From: info@sabdenparish.org.uk
Sent: 12 September 2019 09:15
To: planning
Subject: Application 320190725 6 Stubbins Lane, Sabden

Planning Application 3/2019/0725 Demolition of existing single-storey dwelling and construction of one new, two-storey, three-bedroom replacement dwelling. (Resubmission of application 3/2019/0235) at 6 Stubbins Lane, Sabden

Sabden Parish council object to the proposal for the following reasons :

SECTION
ELEVATIONS

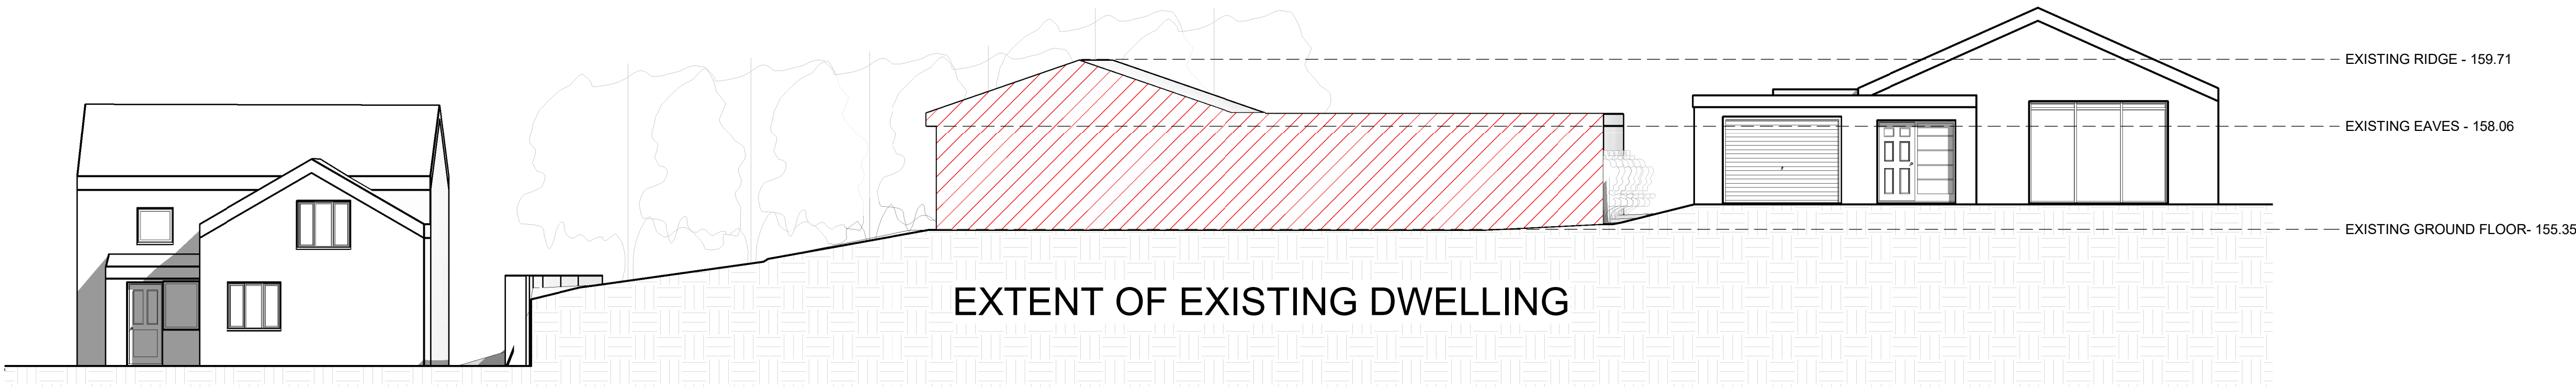
1. The proposed dwelling is within close proximity to No.4 Stubbins Lane will have an overbearing impact on this property. The parish council find it difficult to understand why the building is so close to the boundary retaining wall when the plot is substantial.

The properties at the lower end of stubbins Lane -upto No4 - are two storey, but there is a steeper incline from No4 to No6 - hence a retaining wall of 2.5m between these properties. Hereafter the incline is more gradual and the properties from this point are bungalows.

3. There is a substantial difference in ground levels between No4 & No6 Stubbins Lane and as such there is a dry stone retaining wall approx 2.5m in height between the two properties. The close proximity of the proposed new dwelling to the boundary wall - approx.1m at one end and 2m from the other will impact on the integrity of the wall, which the parish council believe was built circa 18th century. There is already some distress to the wall and that is before any building works have taken place.
